Our ref: STH17/00226/02
Contact: Rachel Carocci 4221 2423
Your ref: SSD8980

14 September 2018

**STATE SIGNIFICANT DEVELOPMENT 8980 – LOT 4 DP 858938, 97-103 BOWRAL ST, BOWRAL -
BOWRAL AND DISTRICT HOSPITAL REDEVELOPMENT**

Figure 46: Proposed general/emergency vehicle access routes (Source: MSJ & GTA)

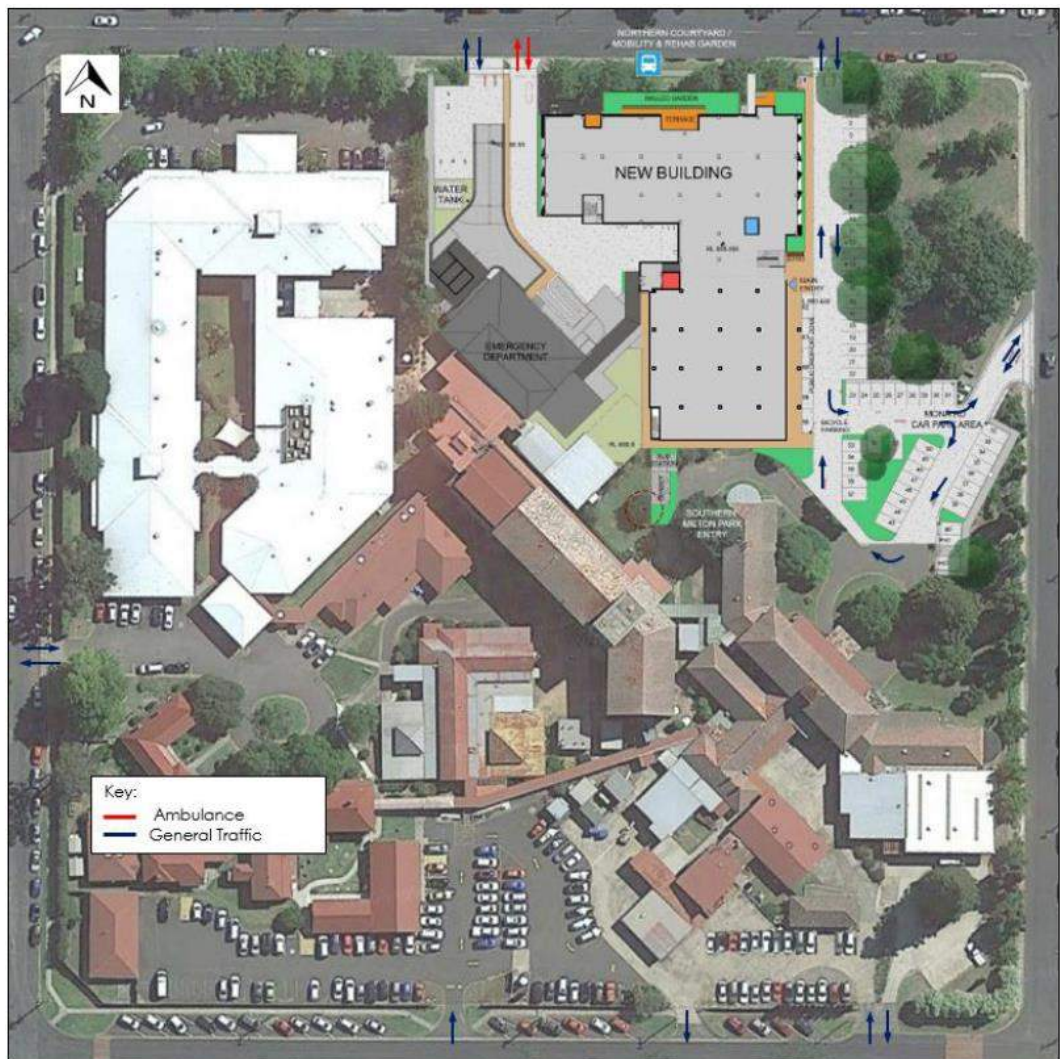
- RMS notes a new access is proposed on Bowral Street. A scaled plan is required showing the existing and proposed access, parking and pedestrian arrangements.

- Vehicles must be able to enter and exit the development in a forward direction. A swept path analysis is required in accordance with Austroads turning templates to demonstrate that the largest vehicle likely to utilise the access can enter and exit the driveway in a forward direction.

- RMS also notes that an existing bus stop is to be relocated to allow for the proposed access on Bowral Street. RMS requires a plan to demonstrate the existing and proposed location of the bus stop.
